EL PASO COUNTY STORMWATER MANAGEMENT PLAN CHECKLIST

EPC Project Number: PPR-22-002

SHEET: 2 OF 5

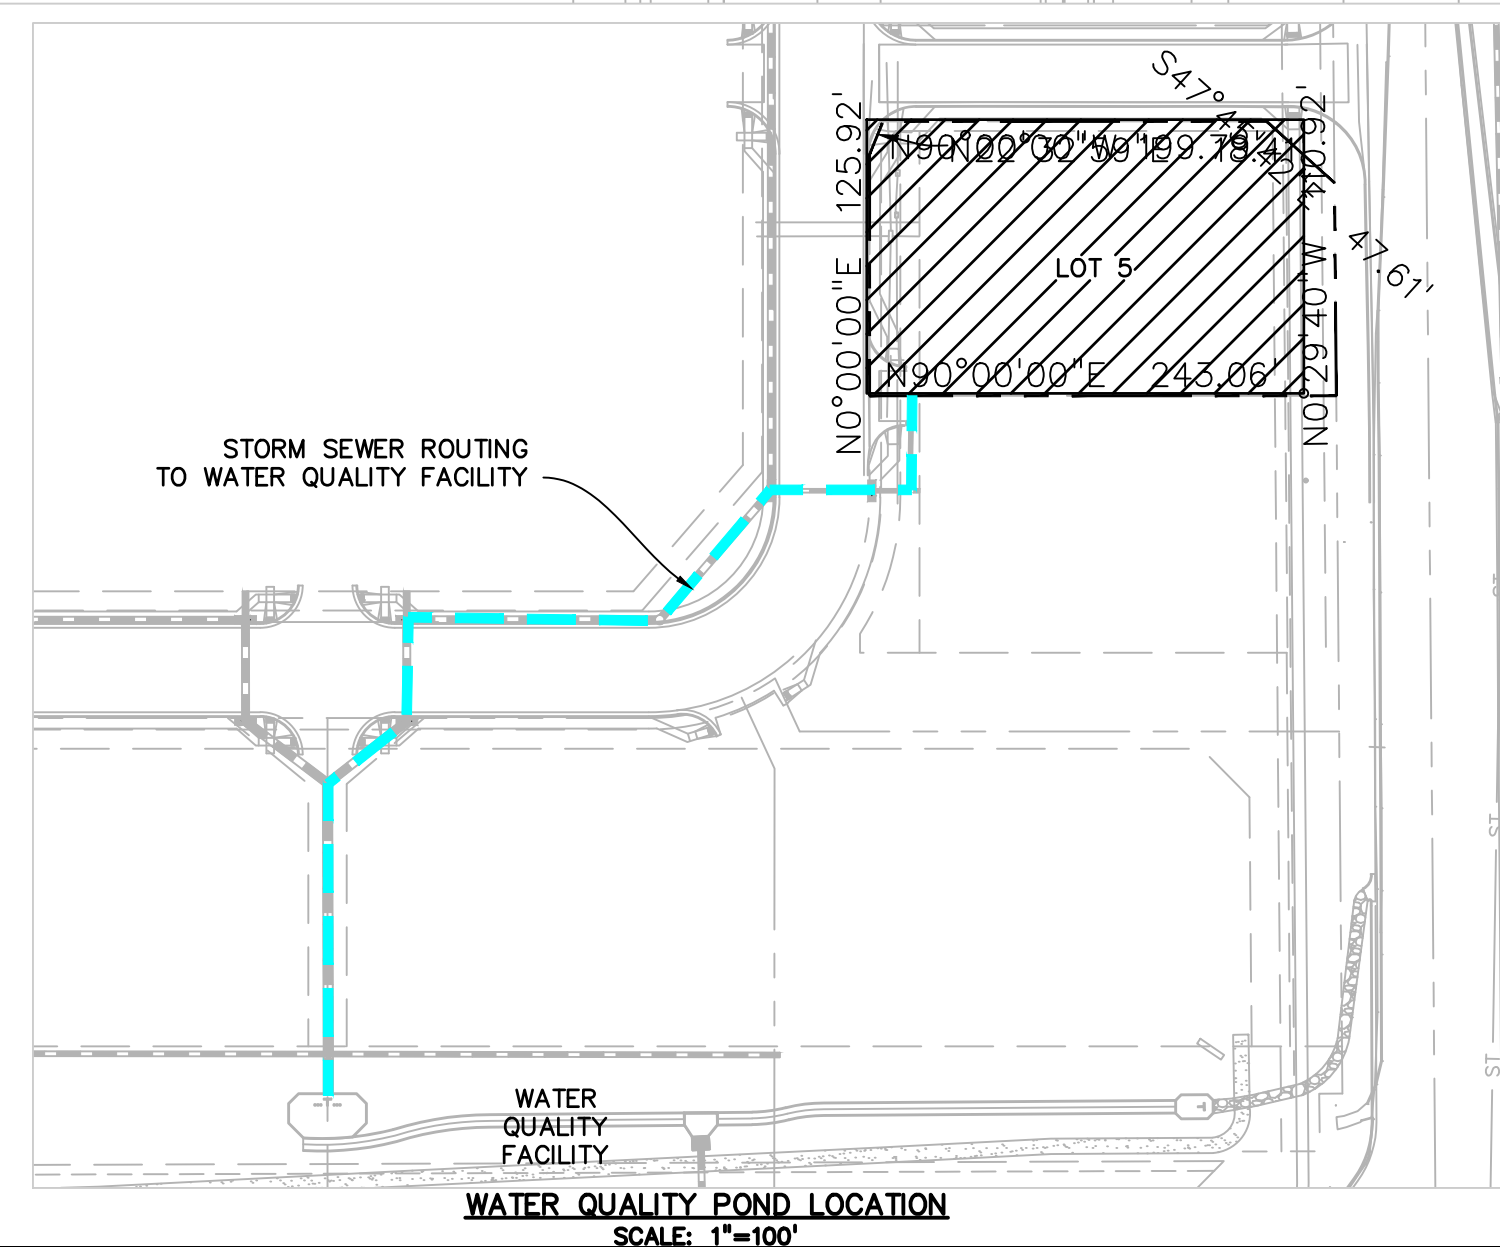
| | | Applicant | EPC |
|---|---|-----------|-----|
| 17 | SWMP Map to include: Reviewed GEC_v1 | | |
| 17f | location of any dedicated asphalt / concrete batch plants | ● | ✗ |
| 17i | springs, streams, wetlands and other surface waters, including areas that require maintenance of pre-existing vegetation within 50 feet of a receiving water | | ✗ |
